**PLANNING ACT 2008
APPLICATION BY HIGHWAYS ENGLAND FOR AN ORDER GRANTING
DEVELOPMENT CONSENT FOR THE A303 SPARKFORD TO ILCHESTER
DUALLING
SUBMISSION MADE PURSUANT TO DEADLINE 8**

PLANNING INSPECTORATE REFERENCE TR010036

PLANNING ACT 2008 - APPLICATION BY HIGHWAYS ENGLAND FOR AN ORDER GRANTING DEVELOPMENT CONSENT FOR THE A303 SPARKFORD TO ILCHESTER DUALLING

SUBMISSION MADE PURSUANT TO DEADLINE 8

2.11 Outline Drainage Works Plans

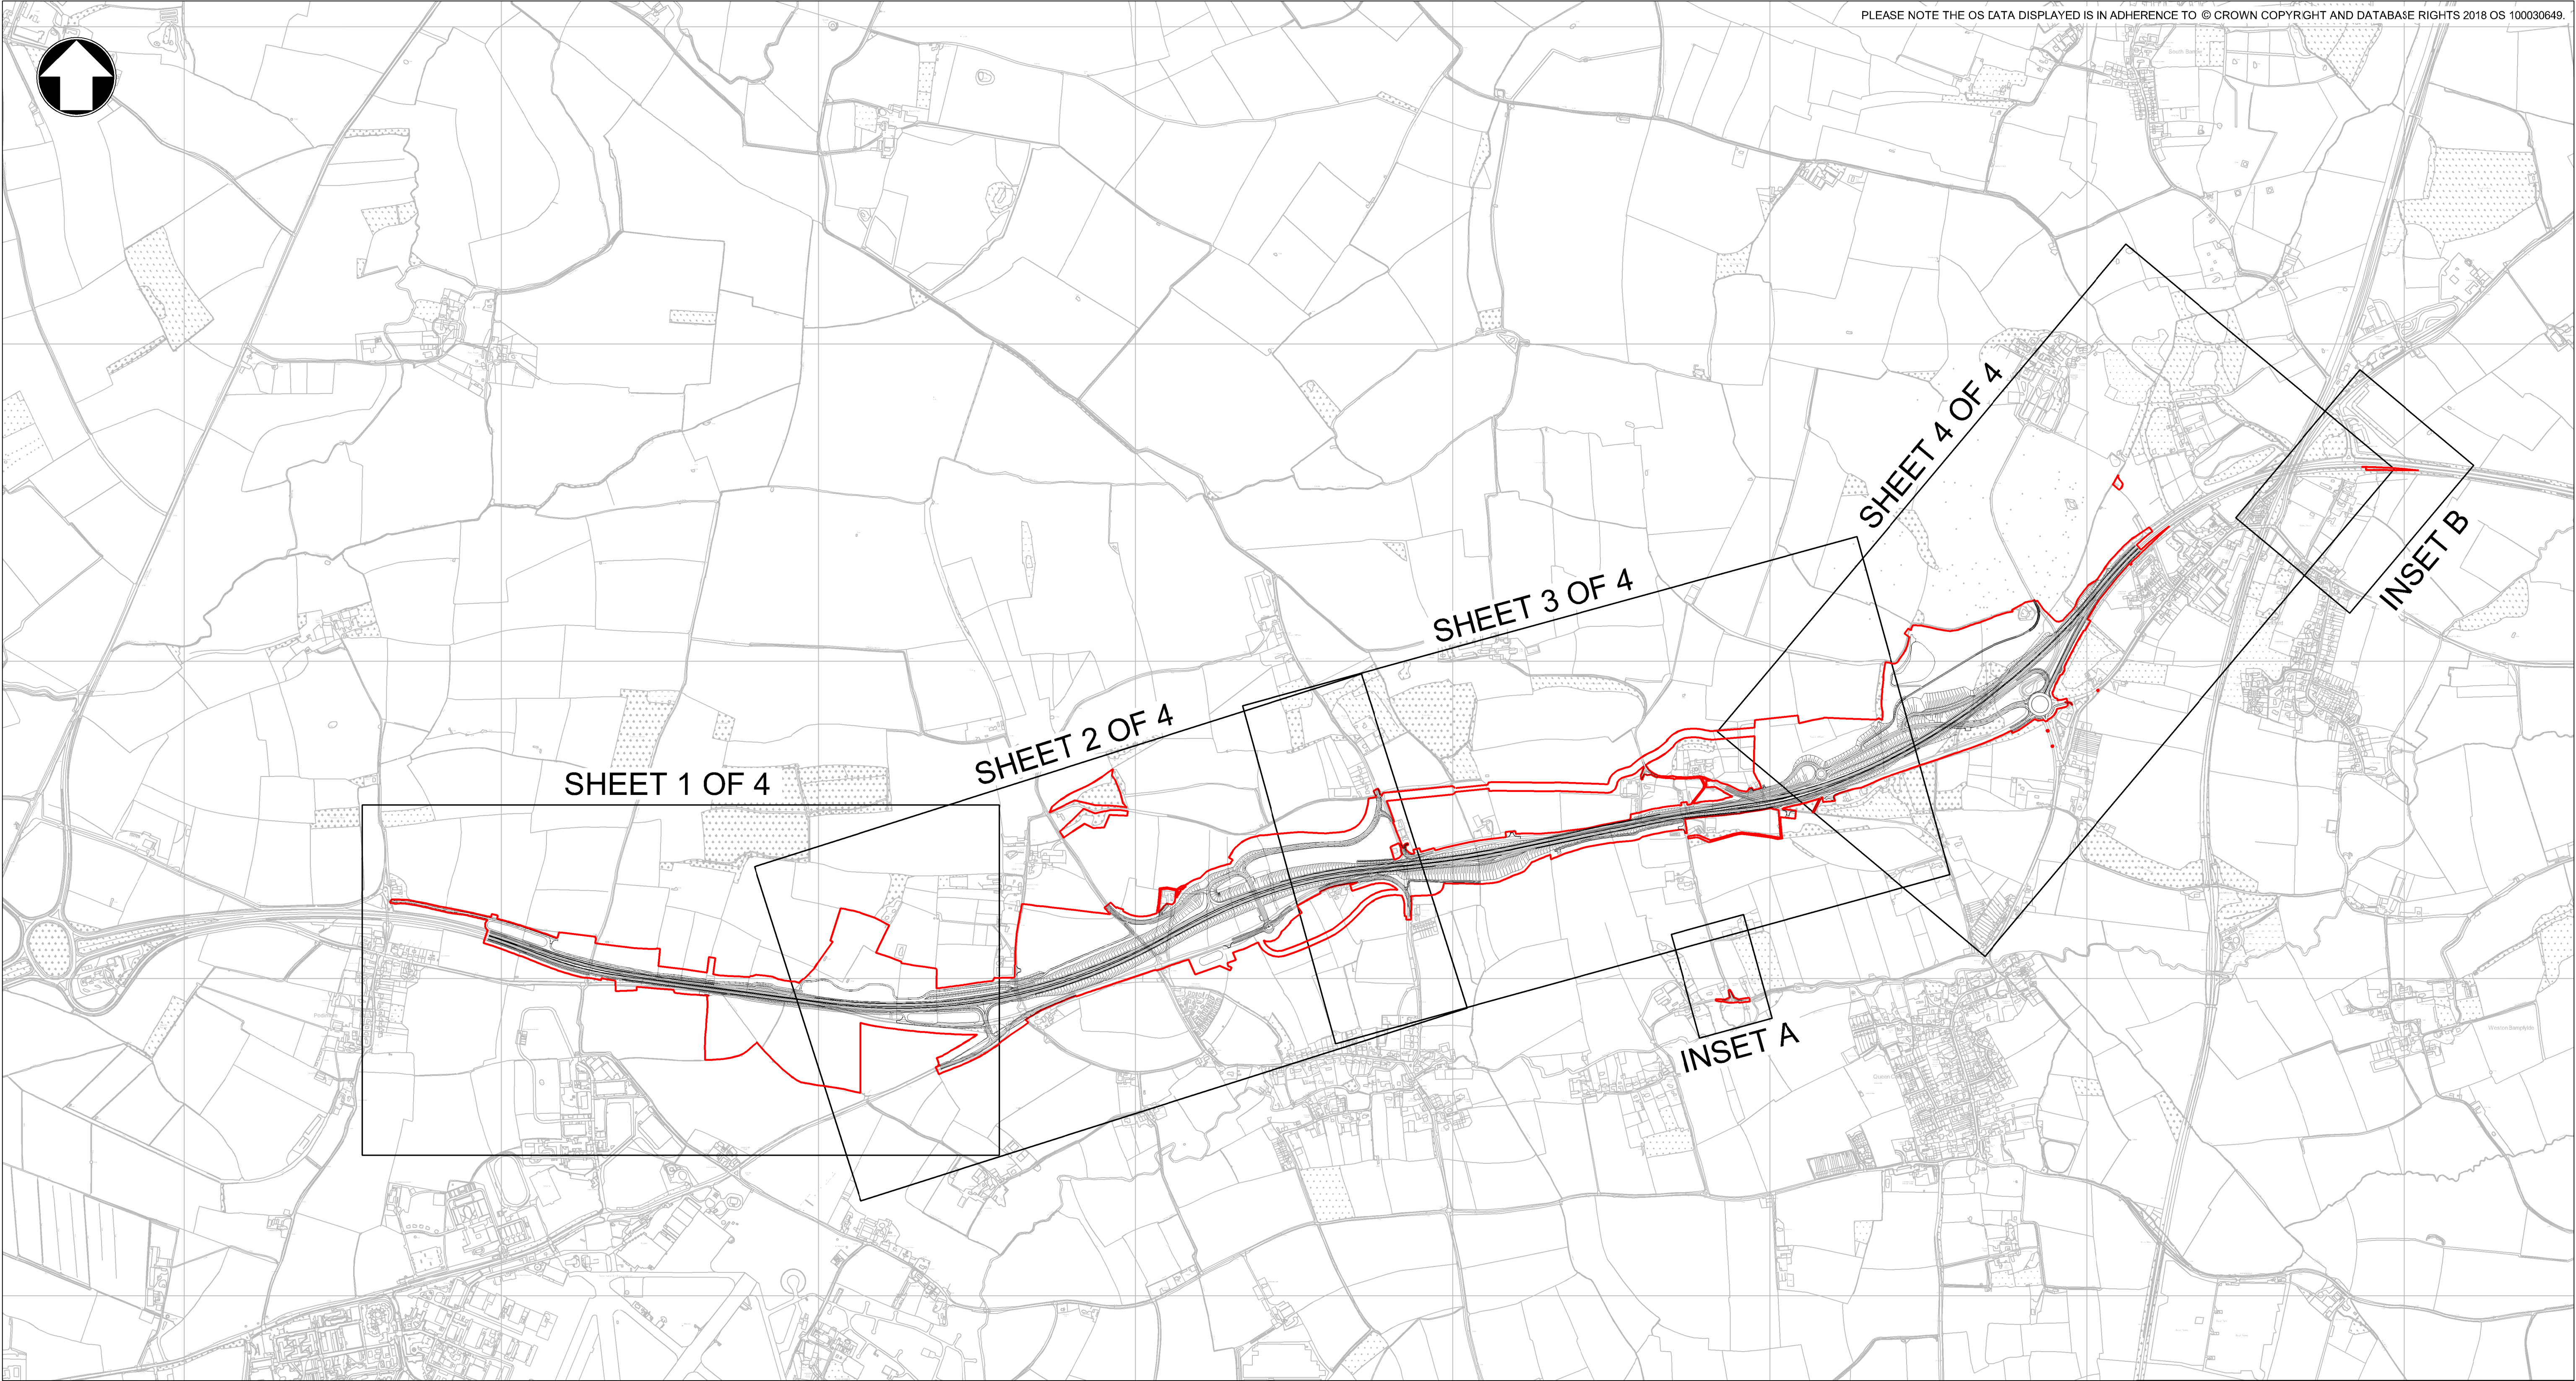
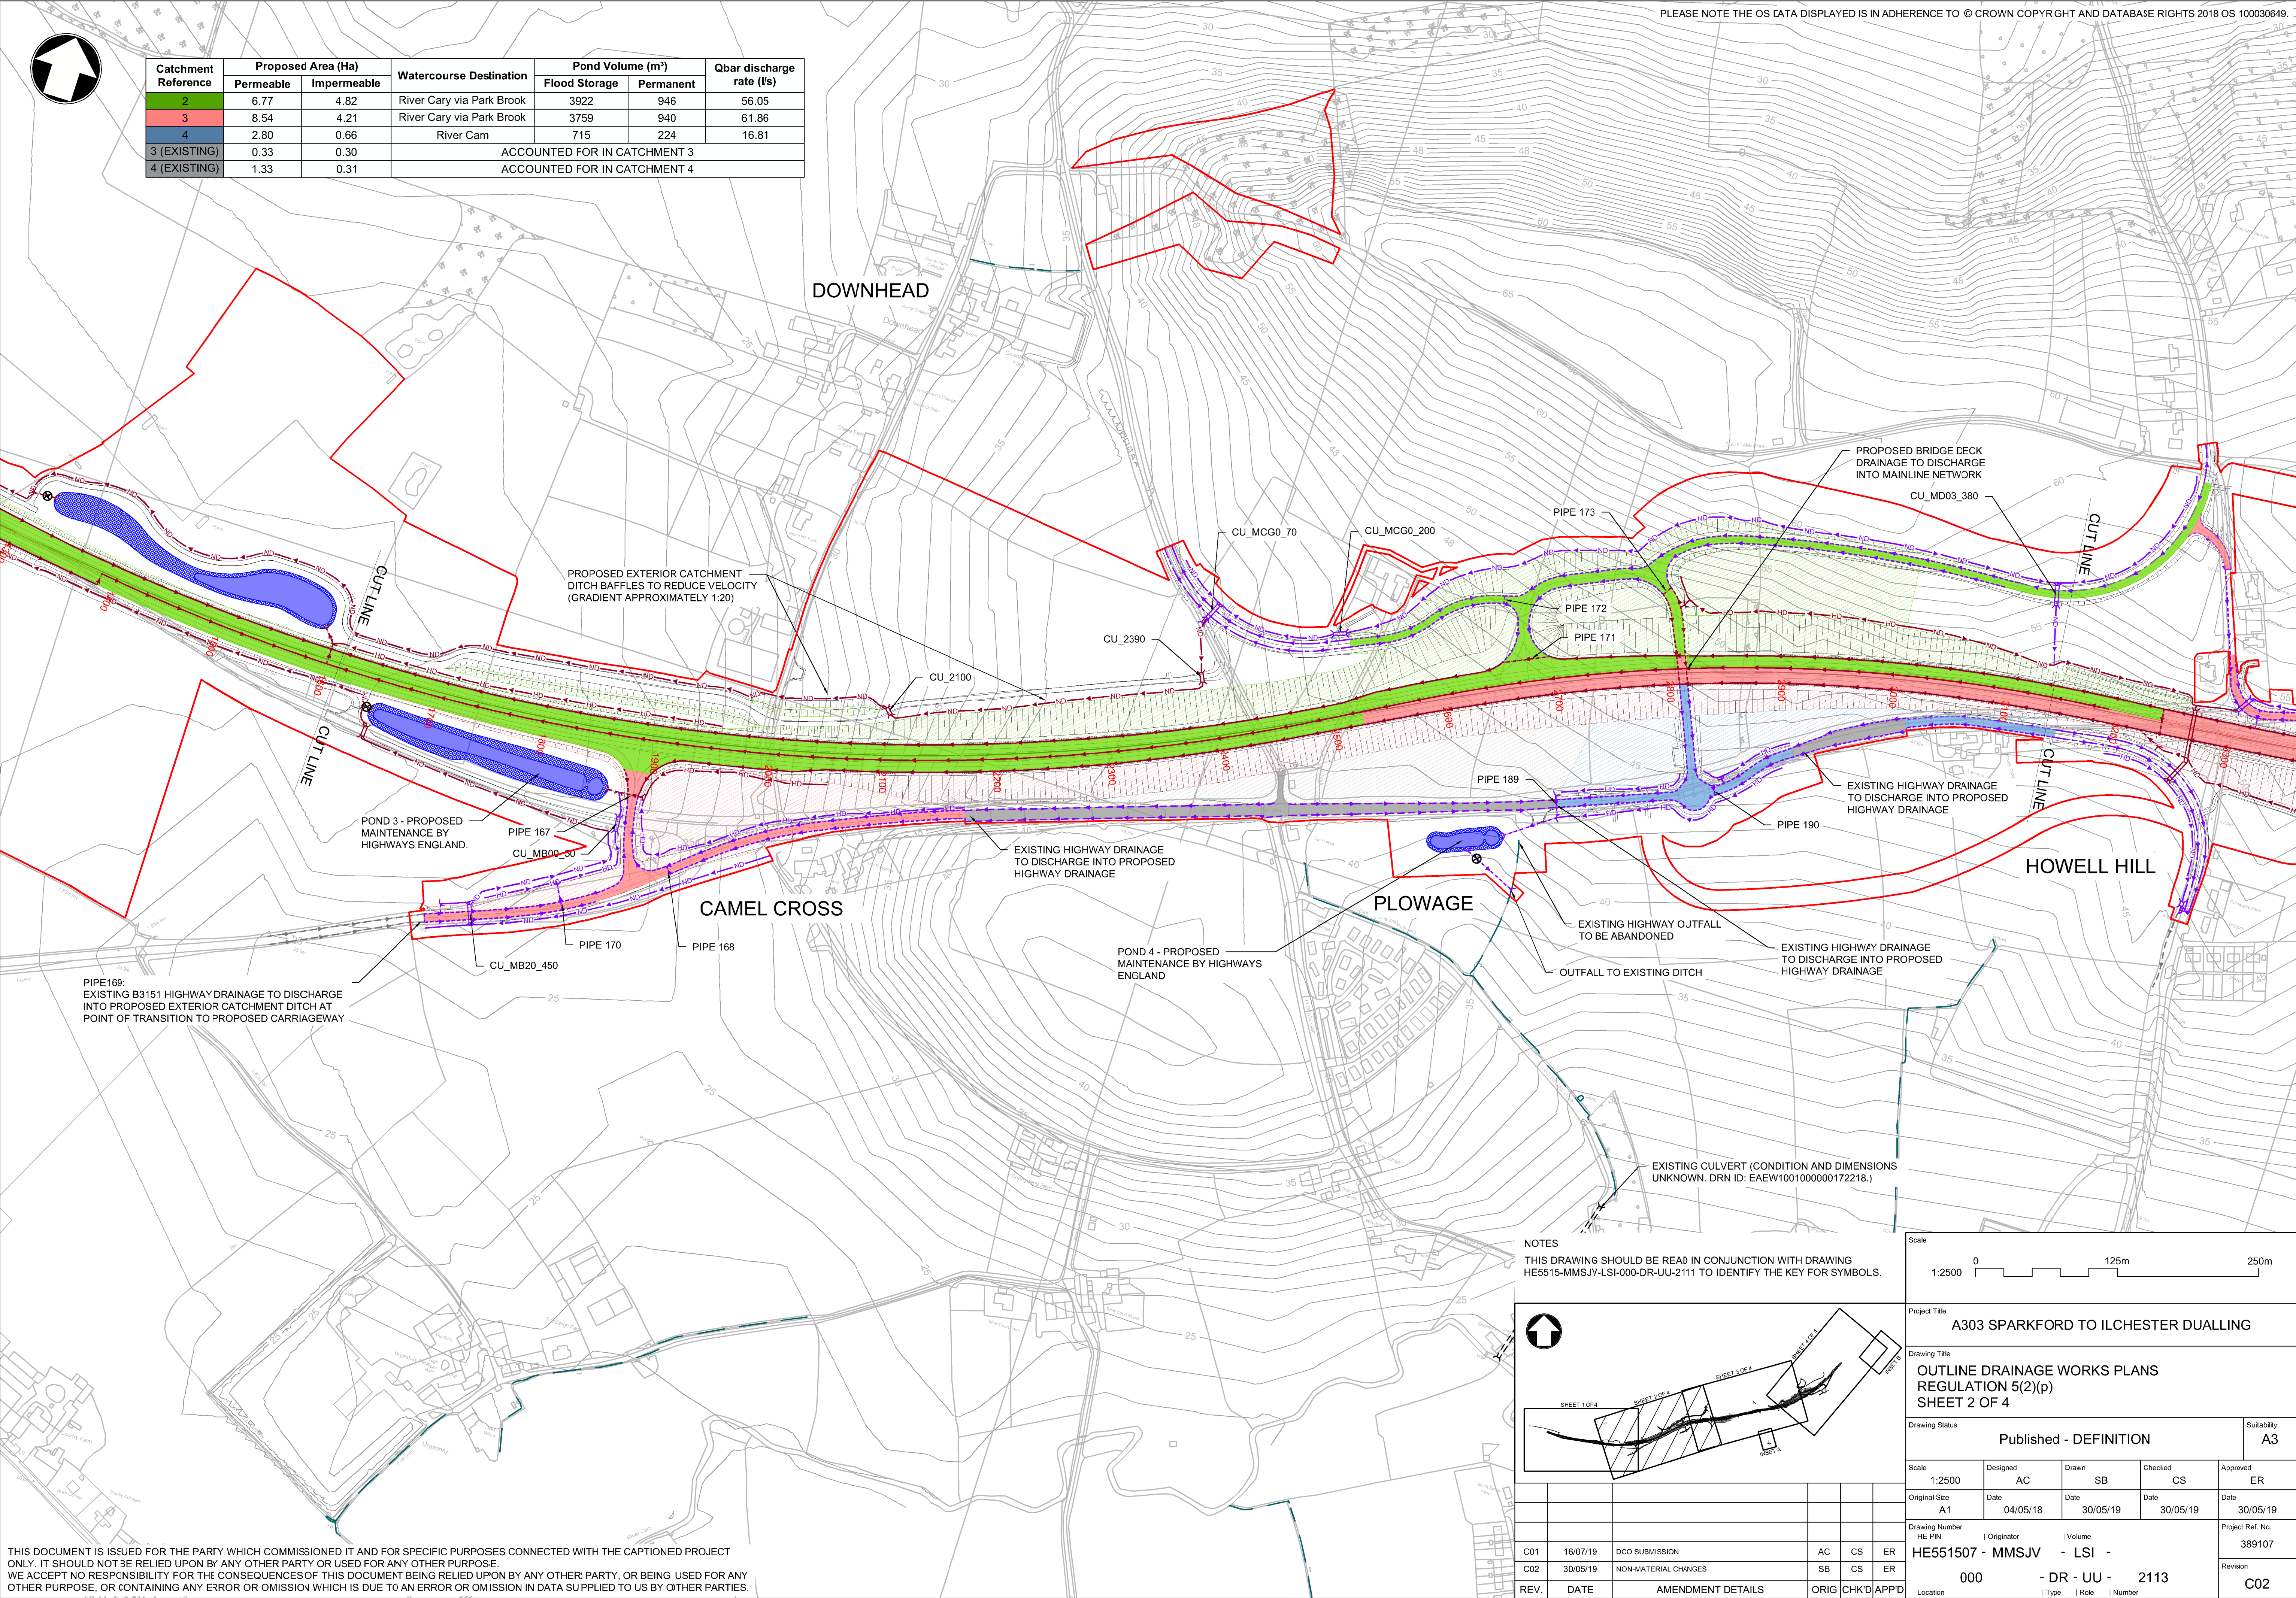
Taking drainage as an example - The Outline Drainage Works Plans separate the highway drainage into catchment areas. The catchment areas discharge to one of the 5 no attenuation ponds. The exception is at tie-in points of new construction with minor roads where the minimal increase in runoff will most likely discharge to existing ditches or gullies, as per the existing arrangements, though the detailed design will confirm if this will be the case.

In order for the LHA to be satisfied that all drainage works have been completed, the drainage infrastructure from the LRN to the receiving attenuation pond, the construction of the pond itself and the outfall into the adjacent watercourse will need to be fully completed. This will provide the satisfaction to the LHA that the LRN has been completed as per the TA drawings.
